From: [REDACTED]
To: [A303 Stonehenge](#)
Cc: [A303Stonehenge](#)
Subject: A303 Stonehenge PRow - Is a bridleway missing from the Draft DCO and associated access plans
Date: 27 August 2019 11:11:40

To the Planning Inspectorate, A303 Stonehenge

I would like to add my concern to that of Roger Upfold (Upfold 20018352 – see copy email below), on behalf of the British Horse Society (BHS), over the important section of apparently missing bridleway on the draft DCO.

Drawing Title
**RIGHTS OF WAY AND ACCESS PLANS
REGULATION 5(2)(k) & 5(2)(o)
SHEET 4 OF 15**

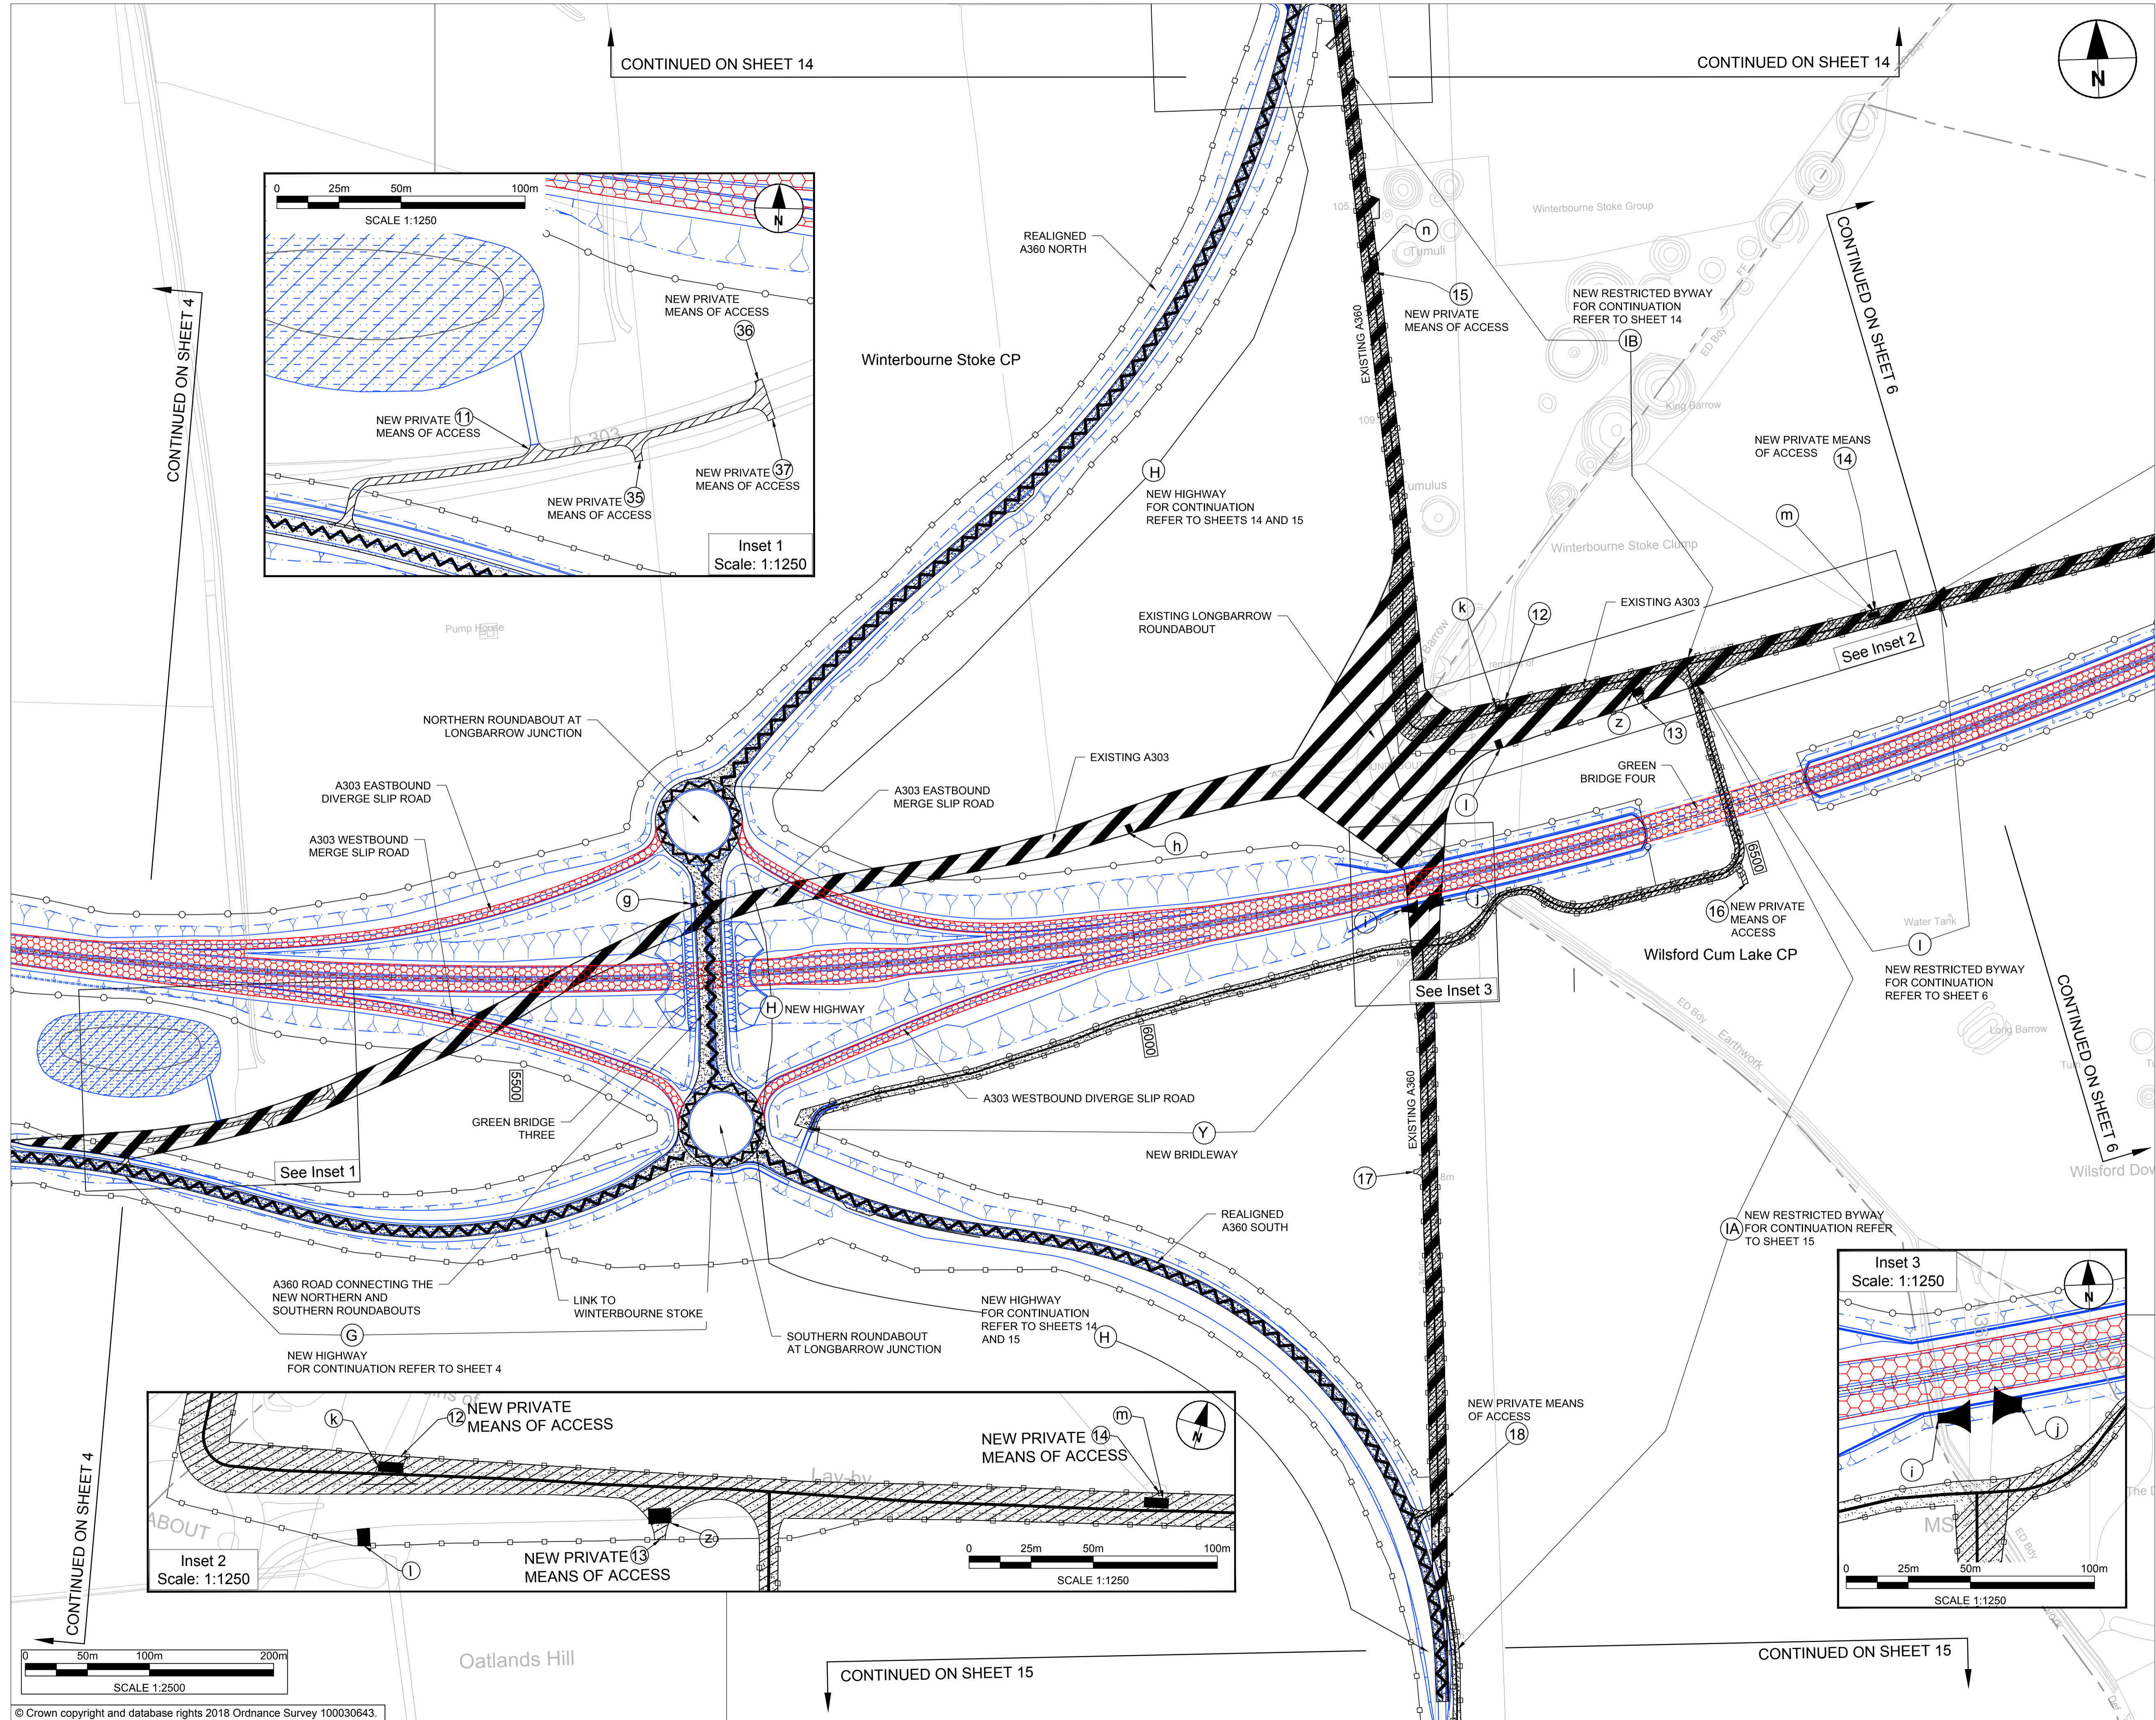
"Reference G A length of new side road between Winterbourne Stoke and the new Longbarrow Junction, from a point 650 metres south west of the existing Longbarrow roundabout (its junction with the new southern roundabout at Longbarrow Junction) in a generally westerly direction to a point 275 metres east of its junction with the byway WST06B, 1.20 kilometres to the south west of the existing Longbarrow roundabout, a distance of 615 metres (as shown on sheets 4 and 5 of the rights of way and access plans)"

Drawing Title
**RIGHTS OF WAY AND ACCESS
PLANS
REGULATION 5(2)(k) & 5(2)(o)
SHEET 5 OF 15**

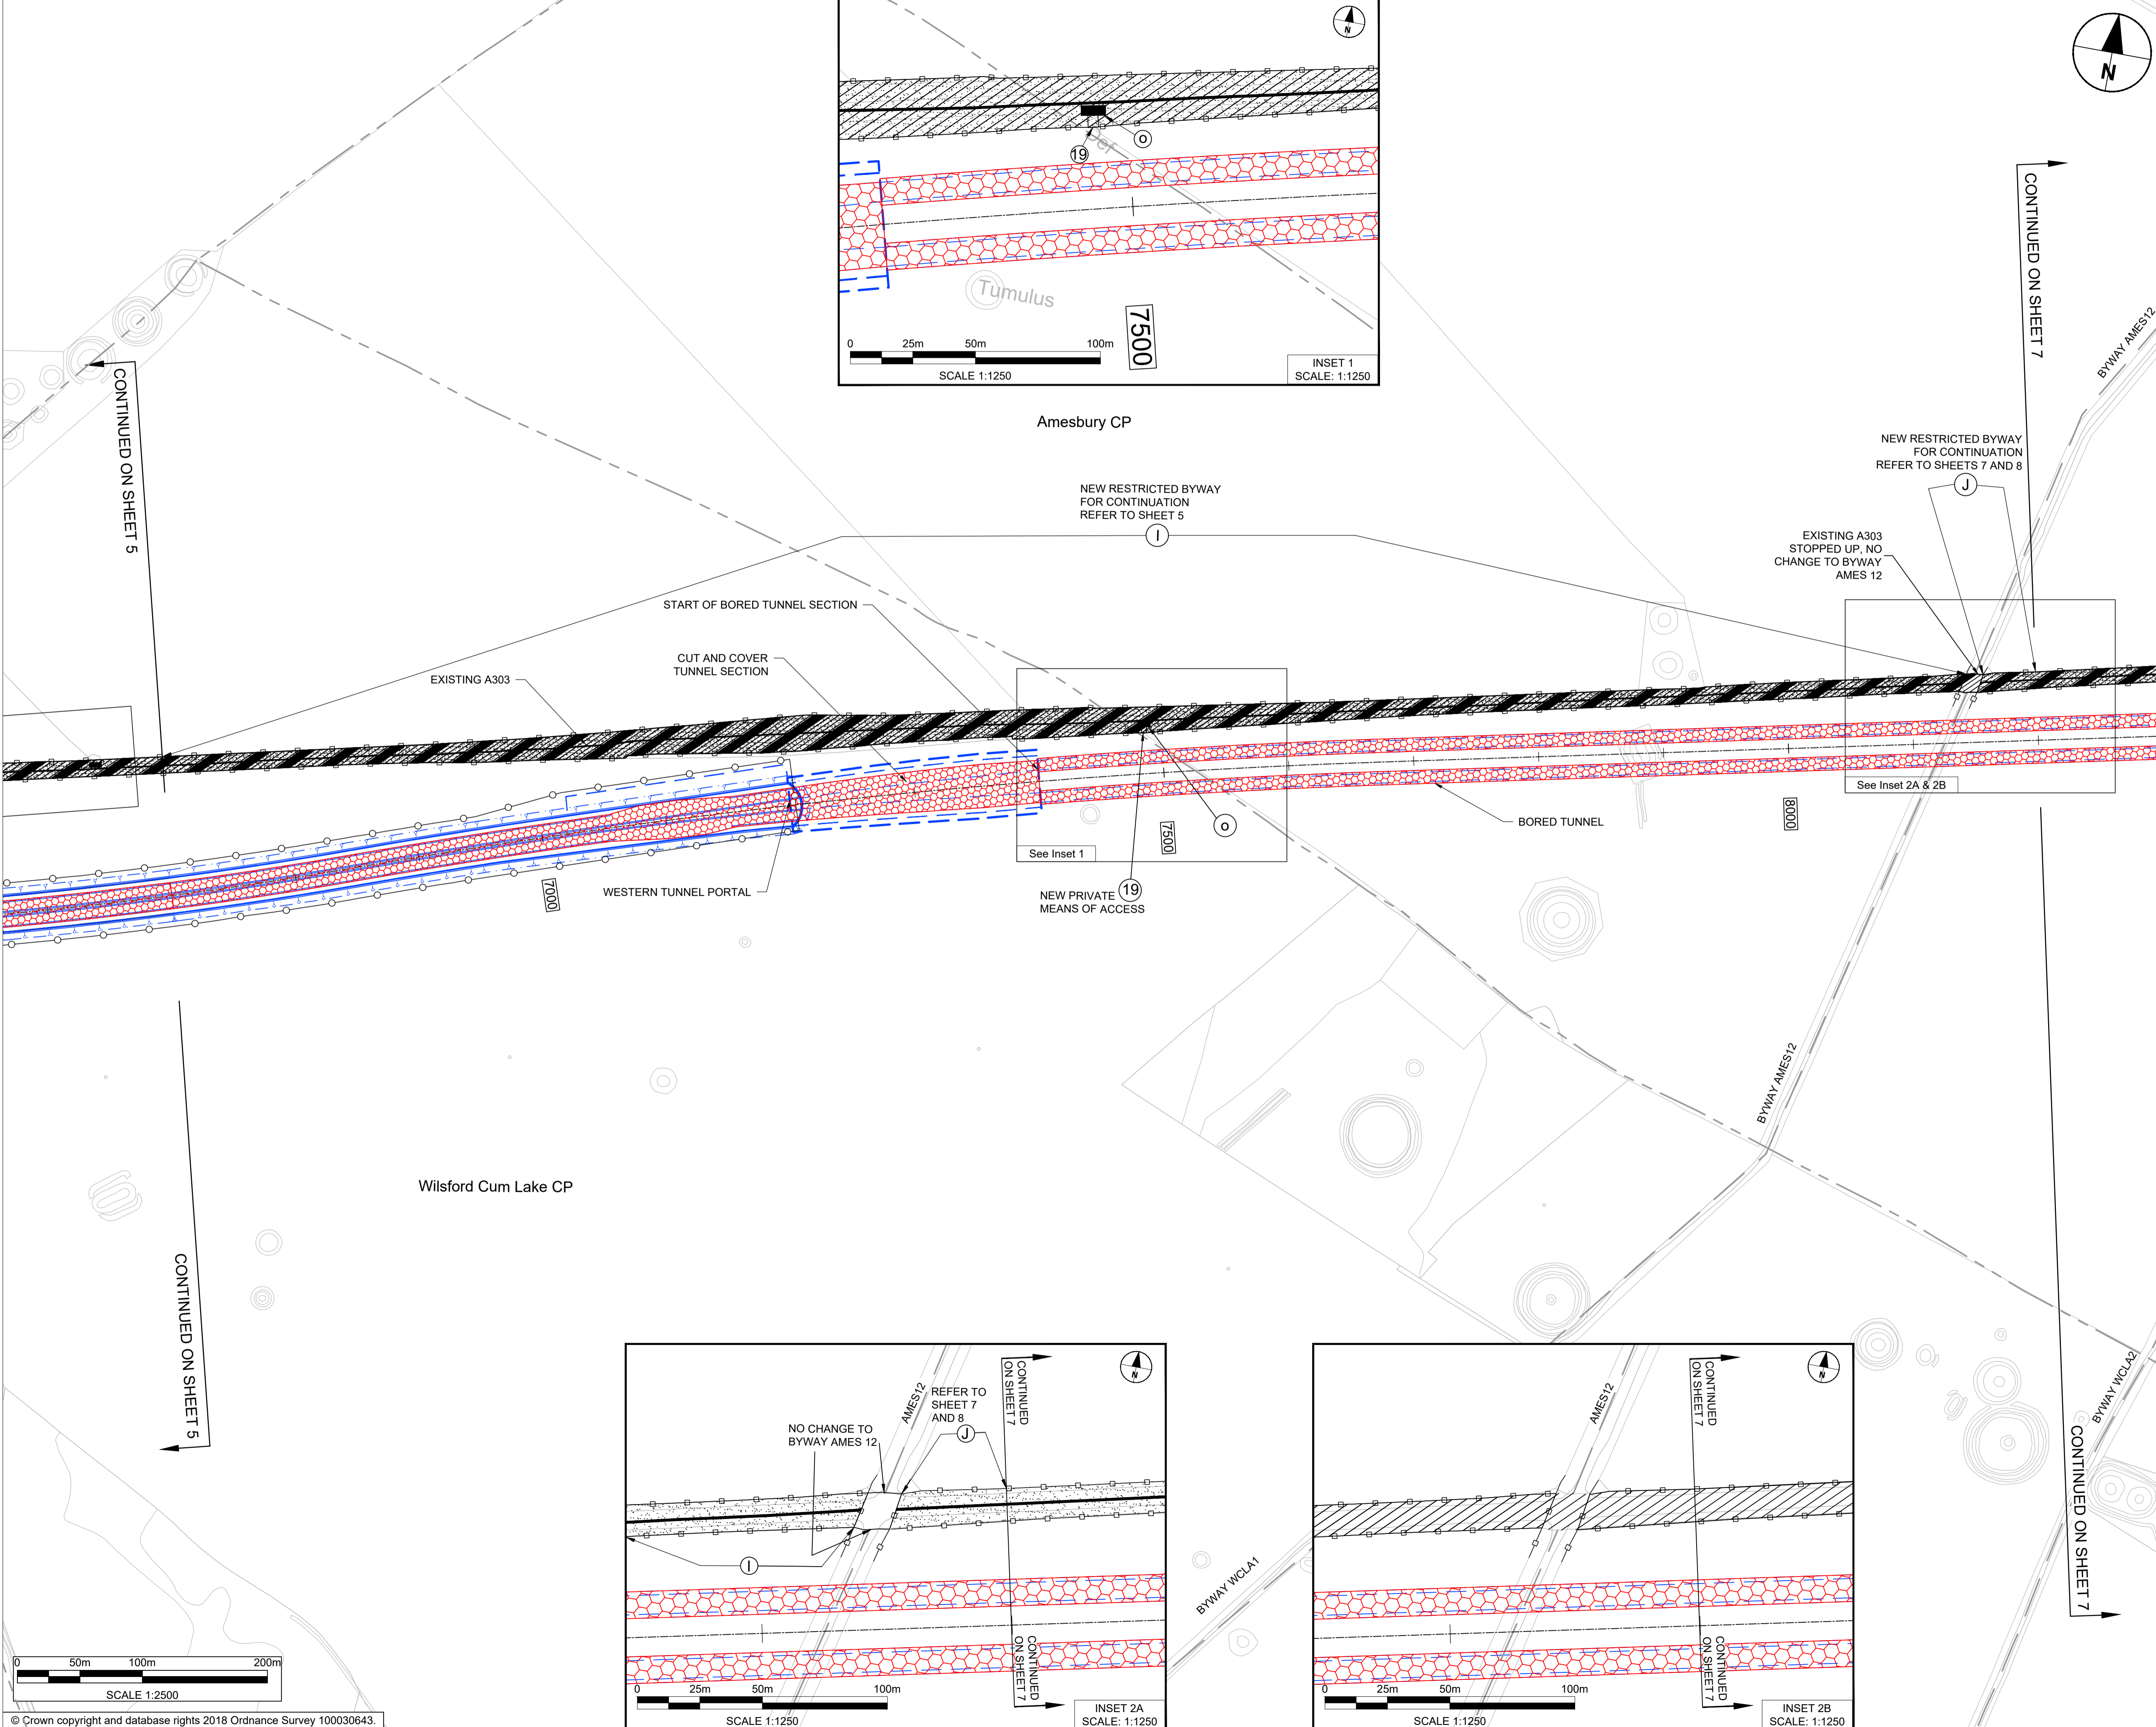
The draft DCO appears to be missing a Bridleway for the length of road labelled 'G' in the draft DCO, see page 66 of the draft DCO where it states:

which is shown on sheet 5 of document TR010025-000161-2-6-RightsOfWayAndAccessPlans.pdf,

to join up with the new Bridleway 'Y' (which then links to the east towards Amesbury along the alignment of the A303, as well as north and south alongside the A360).

- north side of the road (such that a Pegasus/Cycle crossing would be needed for the westbound on-slip onto the newly dualled A303), or to the
- south of the new road 'G' to link with new Bridleway 'Y' via a Pegasus/Cycle Crossing.
